City of Albuquerque

RE: ENGINEER'S CERTIFICATION FOR MAESTAS SUBDIVISION (F14-D18)
RECEIVED APRIL 22, 1994 FOR FINANCIAL GUARANTY RELEASE
ENGINEER'S STAMP DATED 4/22/94.

MAESTAS SUBDIVISION
GRADING & DRAINAGE PLAN

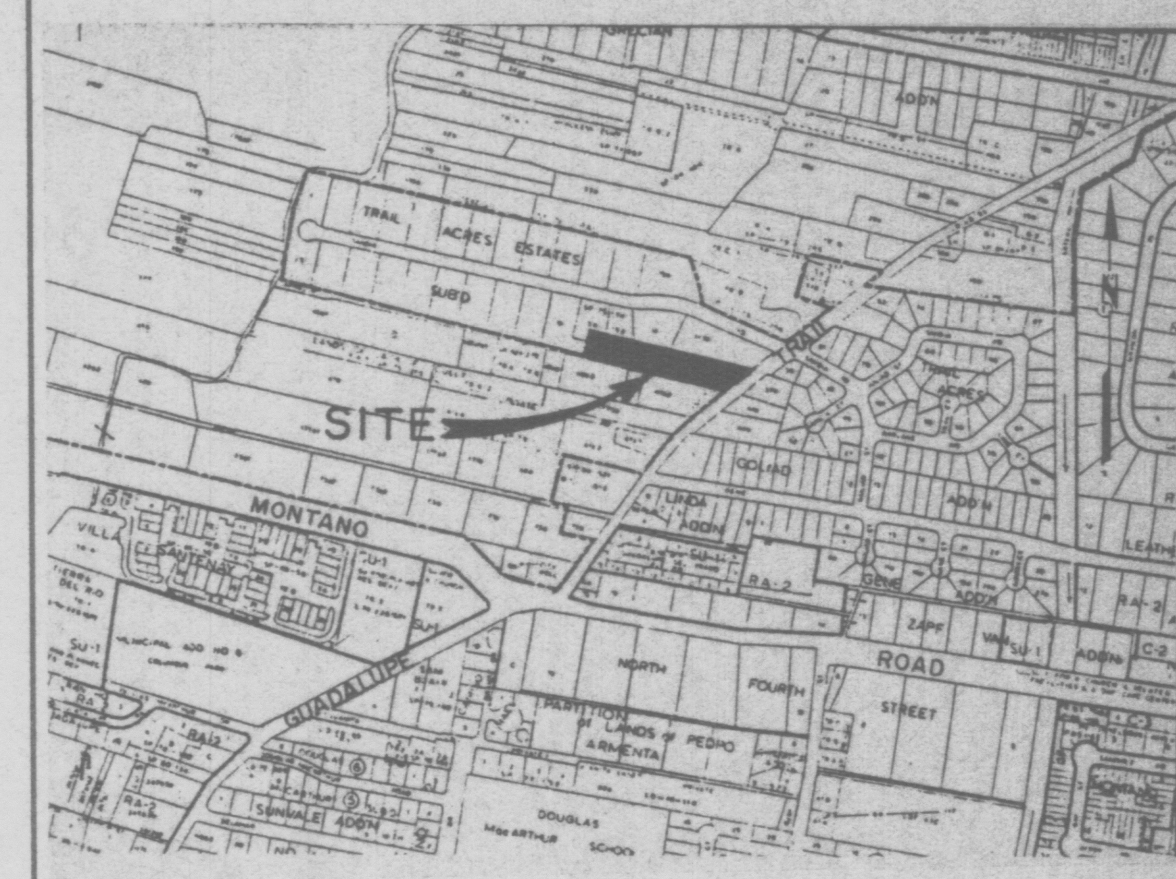
Based on the information included in the submittal referenced above, City Hydrology releases the Financial Guaranty for this project. Due to the flat grading scheme incorporated in this design, City Hydrology waives the requirement for walls between the lots.
